City of Albuquerque

June 26, 1992

RE: DRAINAGE PLAN FOR AN ADDITION TO KASDORF MANUFACTURING, PHASE I
(J-14/D99) ENGINEER'S STAMP DATED JUNE 8, 1992

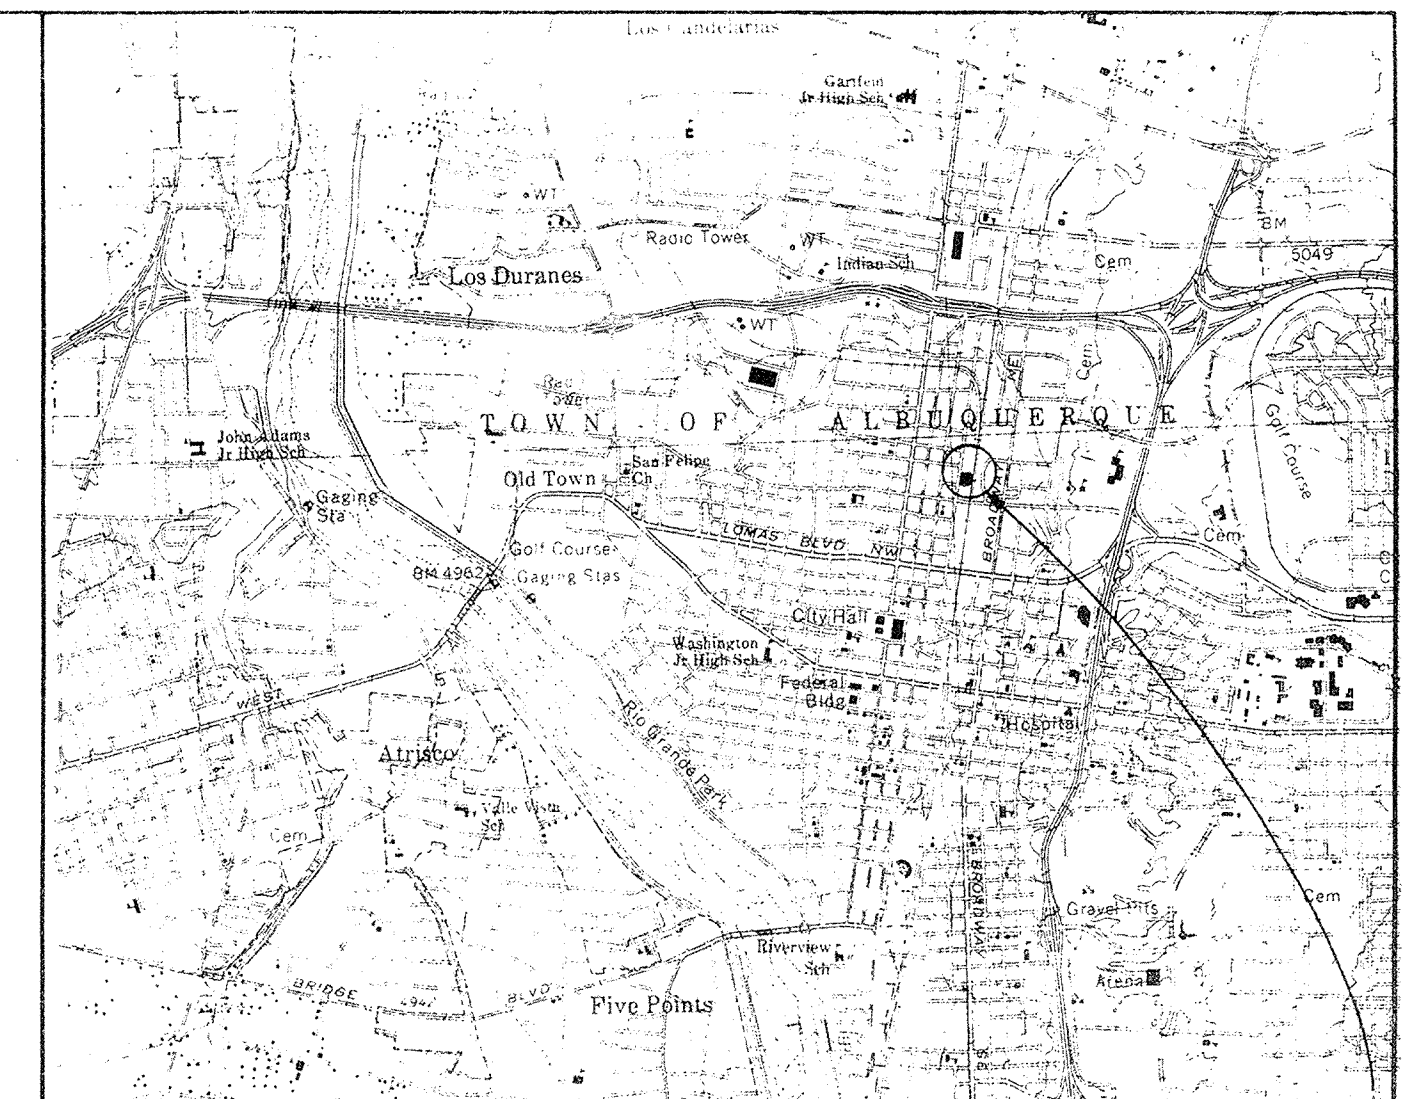
Please be advised that when Phase II submittal is submitted for review, all the developed runoff must be routed to First Street, NW. Catch basin within the parking lot with a tie to the existing inlet on First Street will be appropriate.
